CHERWELL DISTRICT COUNCIL

Representations on Appellant's Revised Unilateral Undertaking and Recommended Conditions

Appellant	:	Gladman Developments
Appeal Site	:	OS Parcels 6741 And 5426 on land west of Cricket Field, north of Wykham Lane, Bodicote
Appellant's Agent	:	N/A
LPA Reference	:	15/01326/OUT
PINS Reference	:	APP/C3105/W/17/3172731

Job No	Drawing No	Revision
GLD011199	SK201-01	P3

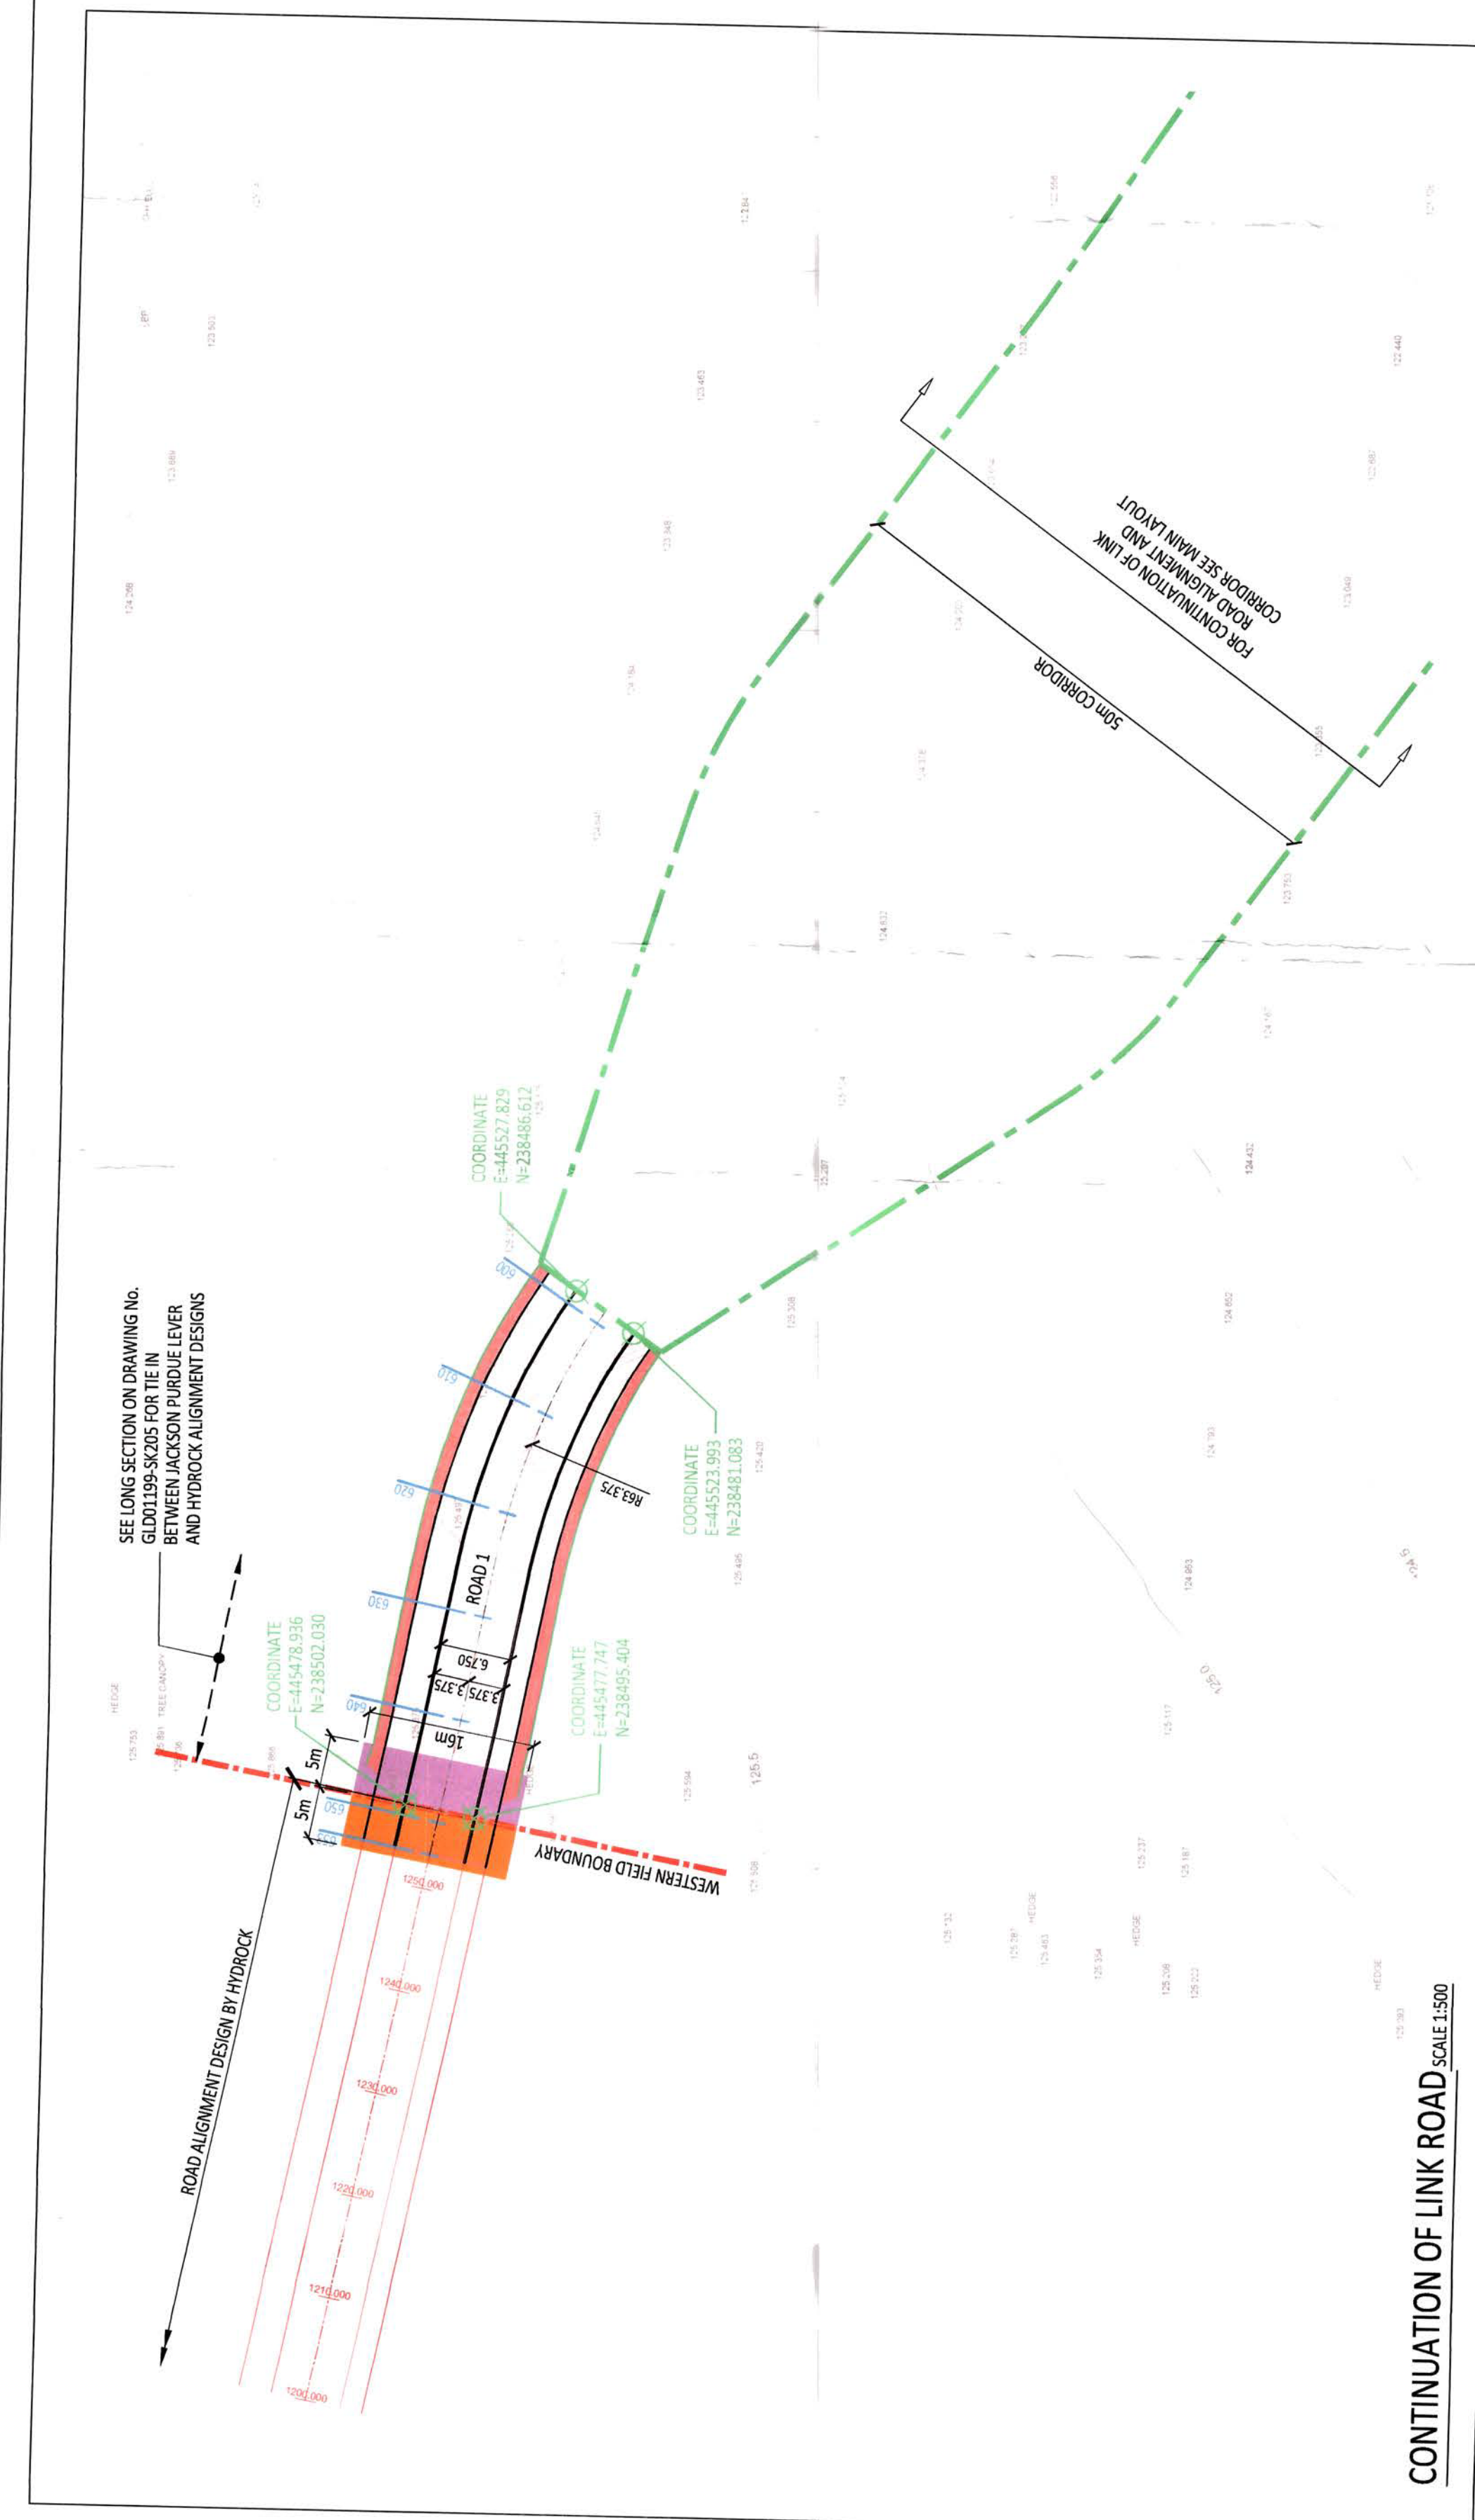
7 – No objection but concern about the appropriateness of referencing what is a separate Unilateral Undertaking within a condition. A planning permission should be able to be understood on its face without having to refer to other legal agreements. This wording *“to the coordinates agreed within Annex 2 of the Unilateral Undertaking”* should therefore not be included within the condition in the Council’s view.

Rev No	GLD01199	Drawing No	SK205	Revision	P2
--------	----------	------------	-------	----------	----

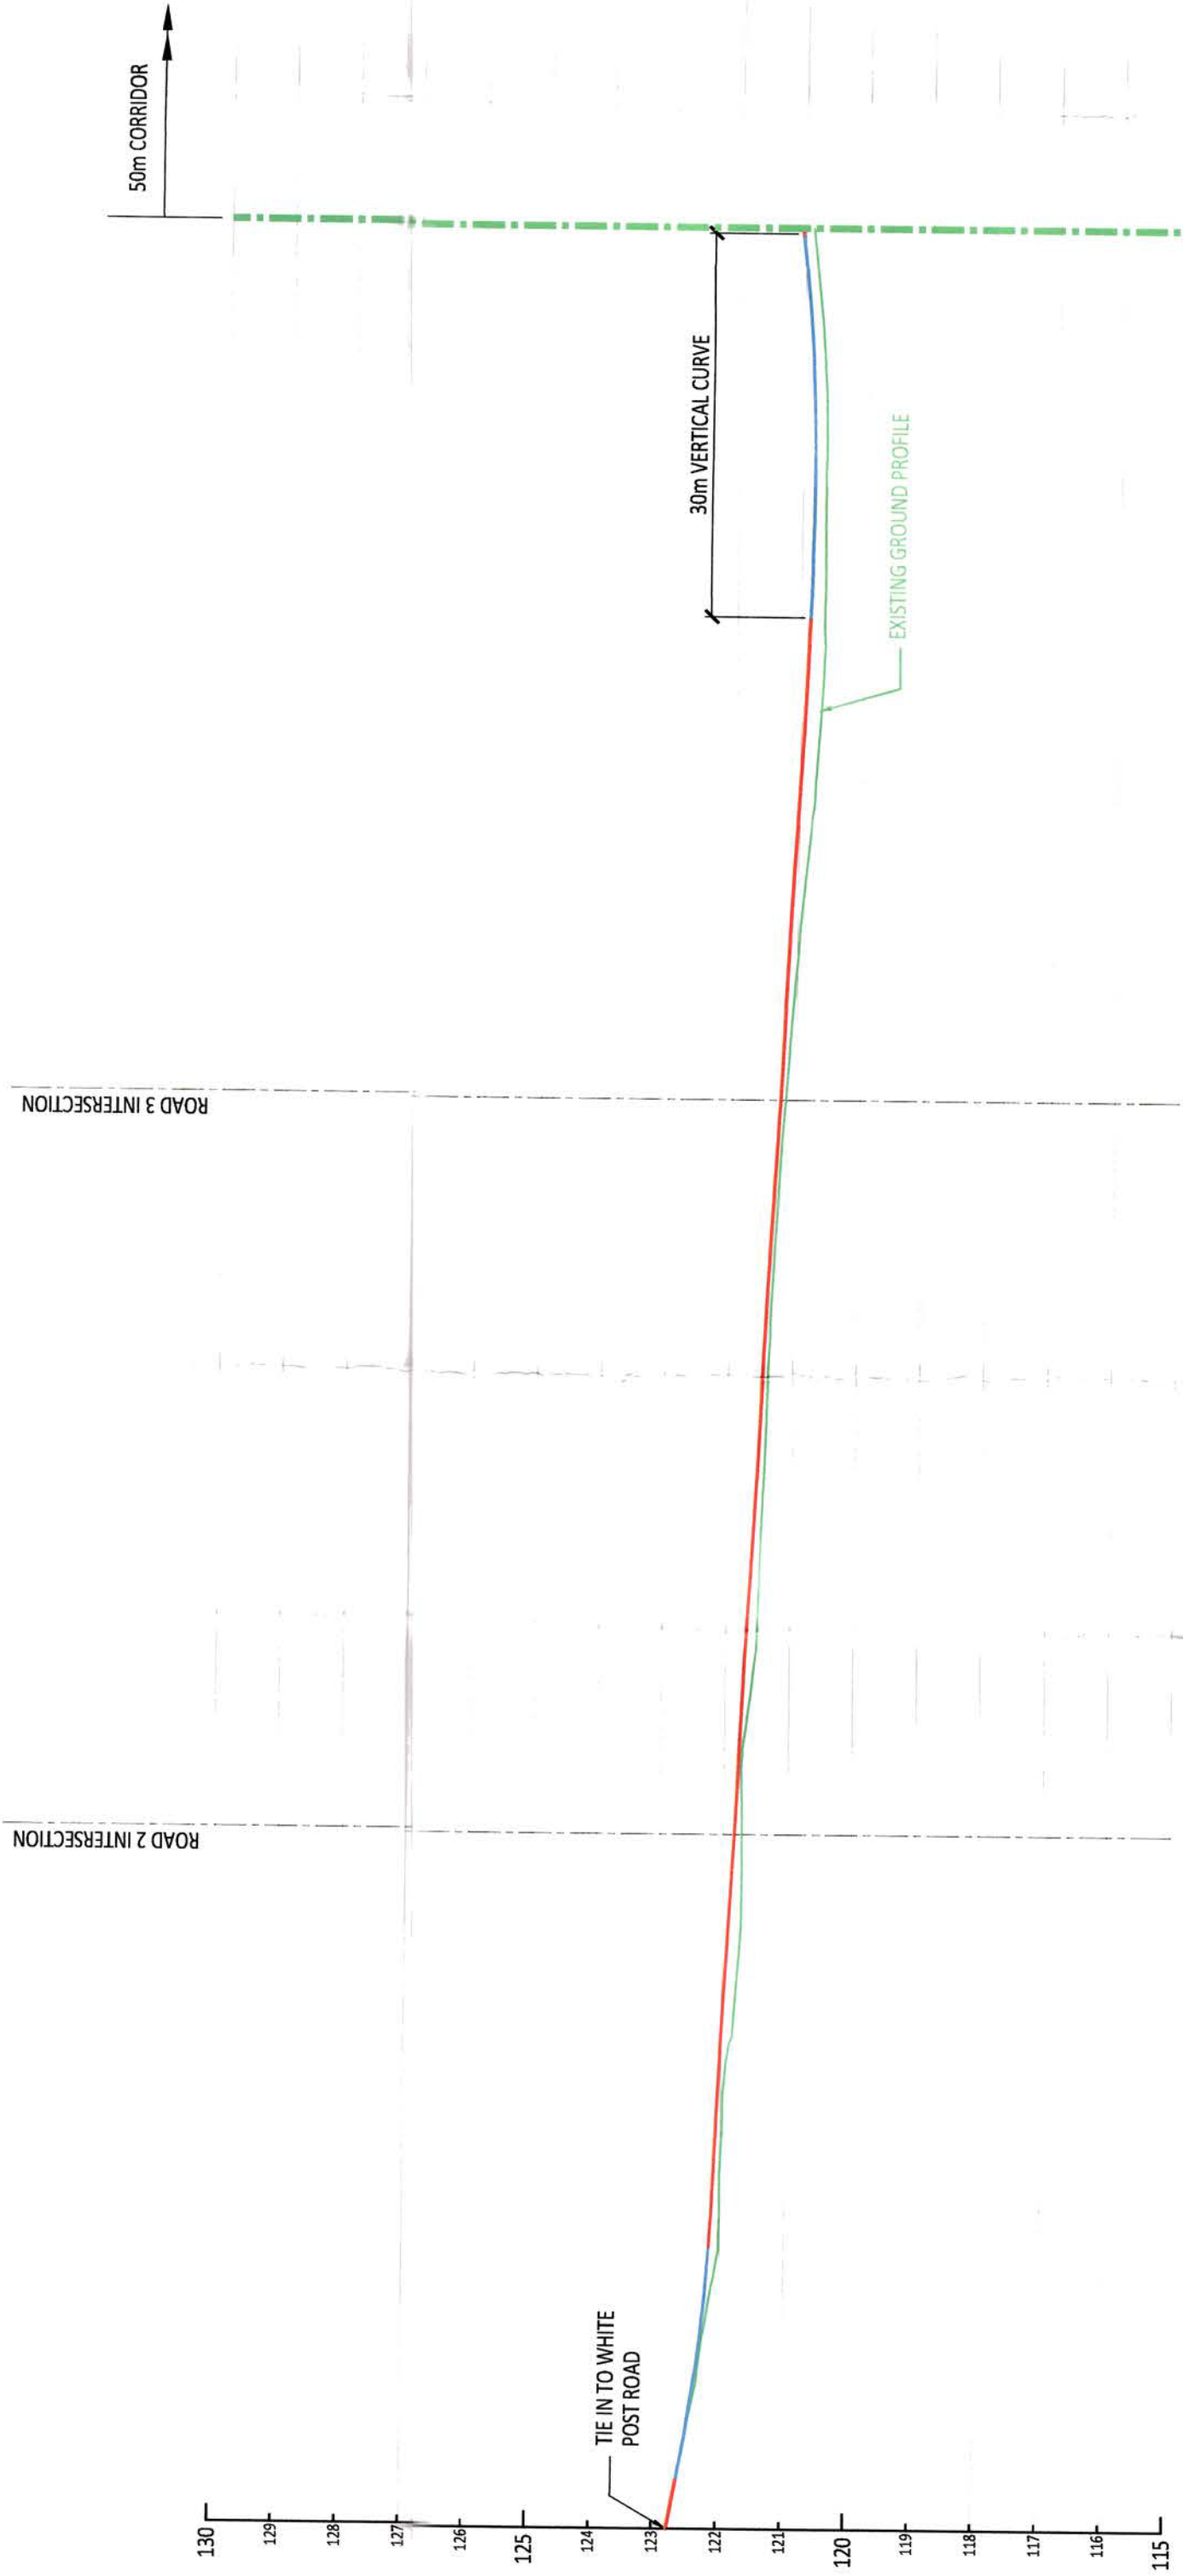
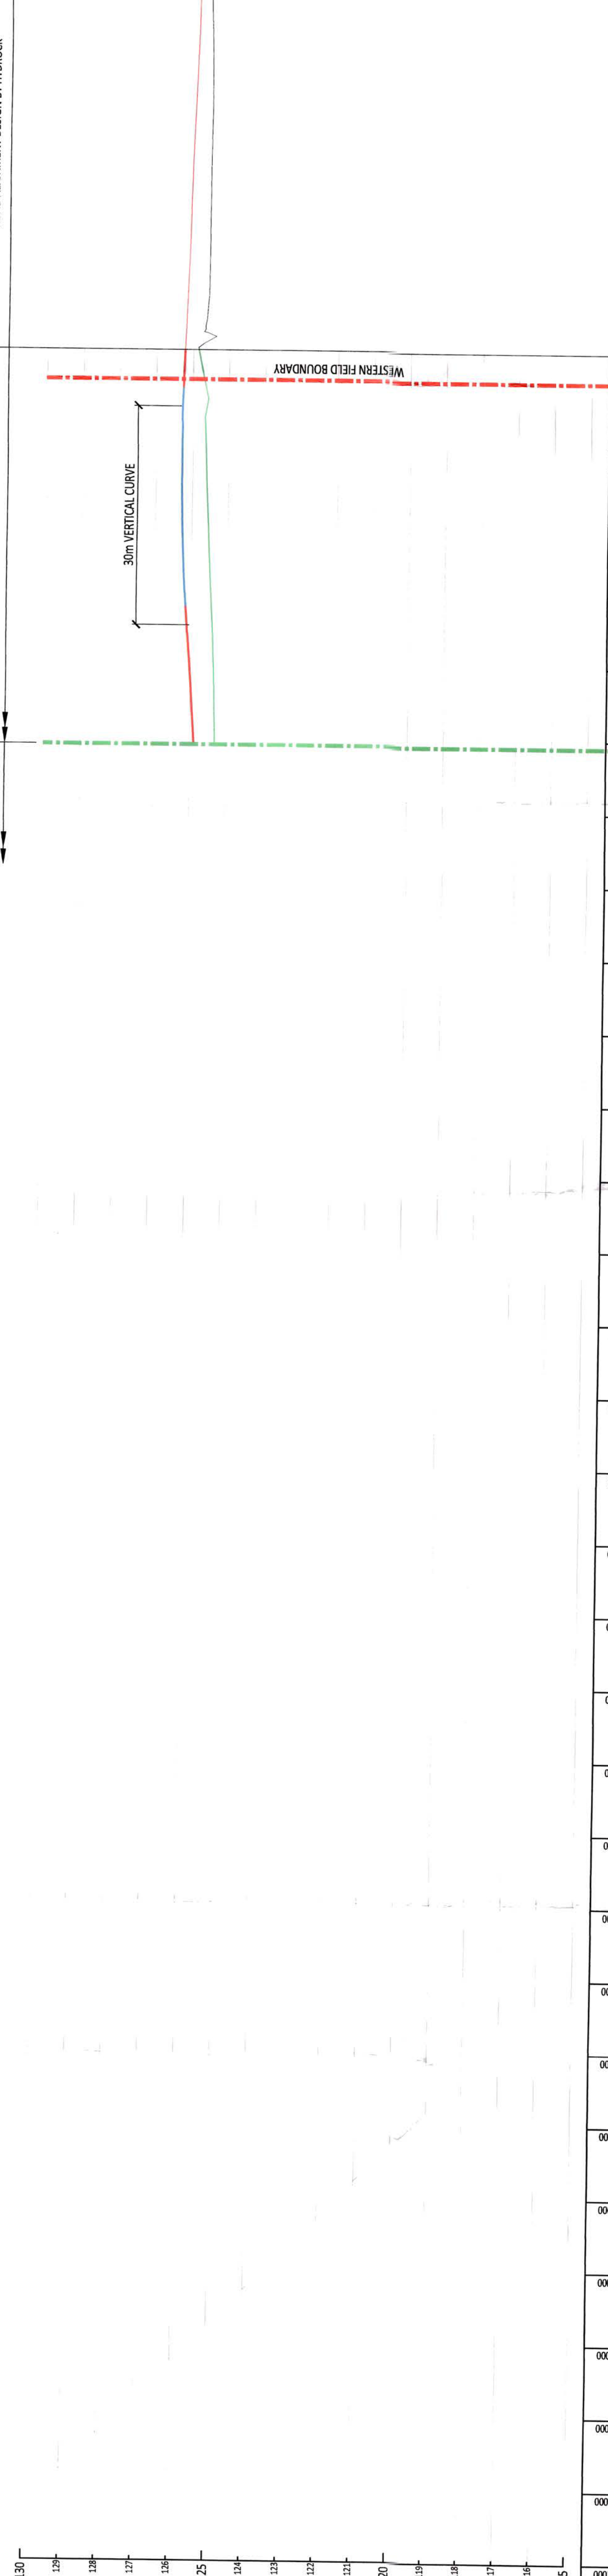
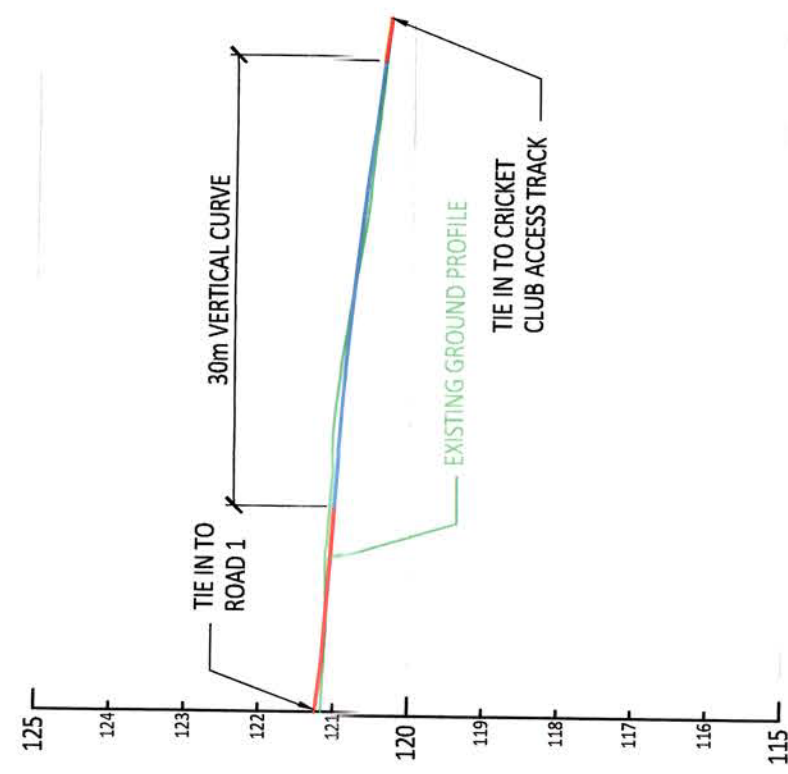
6 – The detailed plans of the link road (long section, connection at western boundary etc) should be included in the list of approved plans. The application does not reserve access and these should not be buried within Unilateral Undertaking appendices for reasons of transparency. The revised Development Framework Plan is now correctly referenced. The Inspector will have to be satisfied that the second paragraph is sufficiently precise to meet the national policy tests.

8 – No objection subject to all drawing numbers for the detailed section of link road being incorporated. The amendment to the trigger so that it reads the 151st dwelling is considered to be acceptable and is consistent with the Council’s position on the planning obligations.
